WEST SUSSEX COUNTY COUNCIL
COUNTY HIGHWAYS CONSULTATION RESPONSE

SUBJECT: LU/426/17/DOC - Approval of details reserved by condition imposed under LU/234/16/RES relating to condition 7 for details of acoustic barrier.

LOCATION: Fitzalan Link Road, East Street, Littlehampton, West Sussex.

This is the second WSCC highways and transport response to the planning application. It follows review of additional information as shown on Drawing's A088461 FL1 & 2[J].dwg produced by WYG Environmental Planning Consultants on behalf of Persimmon Homes.

FL.1

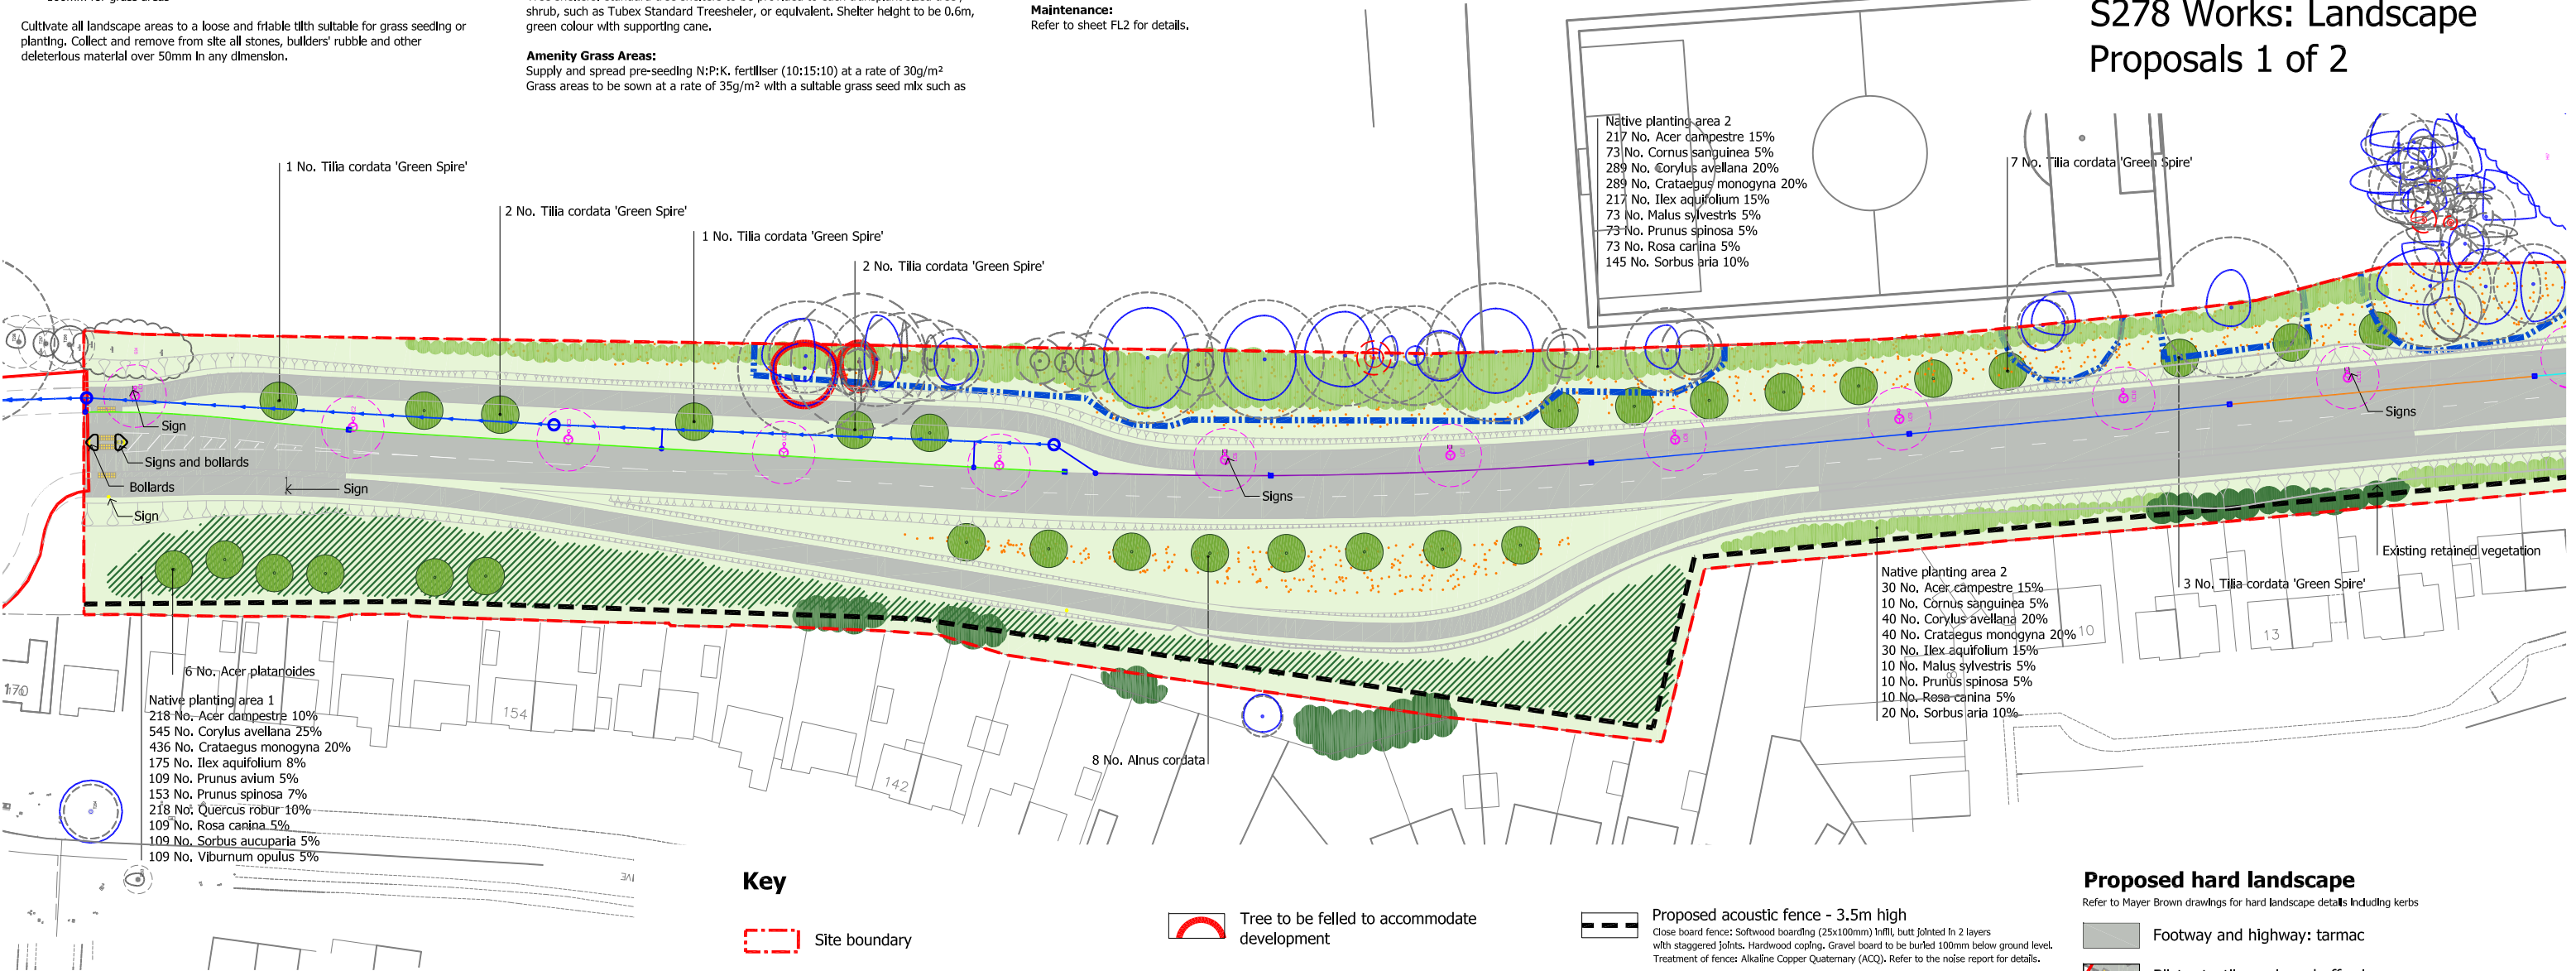
1. Neither the drawings supplied, nor the detailed design drawings adequately specify the topsoil requirements for planted areas. *Applicant to provide details.*

2. The land between the site boundary and the acoustic barrier will need to be levelled, and surfaced with a weed proof membrane and type 1 gravel surface. Amenity grass is not suitable here. *Applicant to confirm that this will be provided.*

3. **A commuted sum will be sought for maintenance of the acoustic barrier and the vegetation, all in accordance with the 60 year CSS/ADEPT process.**
4. There appears to be no allowance for access to maintain the acoustic barrier with plant to replace it at the end of its service life in about 20 years' time. *How does the designer envisage such maintenance will be carried out without disturbing the ecology that will inevitably colonise these areas?*

5. The direction sign at the northern end is shown within the verge/planting area on the detailed sign design. Visibility areas with restricted plant height will need to be cleared on the approach to the sign. *The design needs to be amended to show the sign in its final location and any obstruction of visibility by planting being removed.*
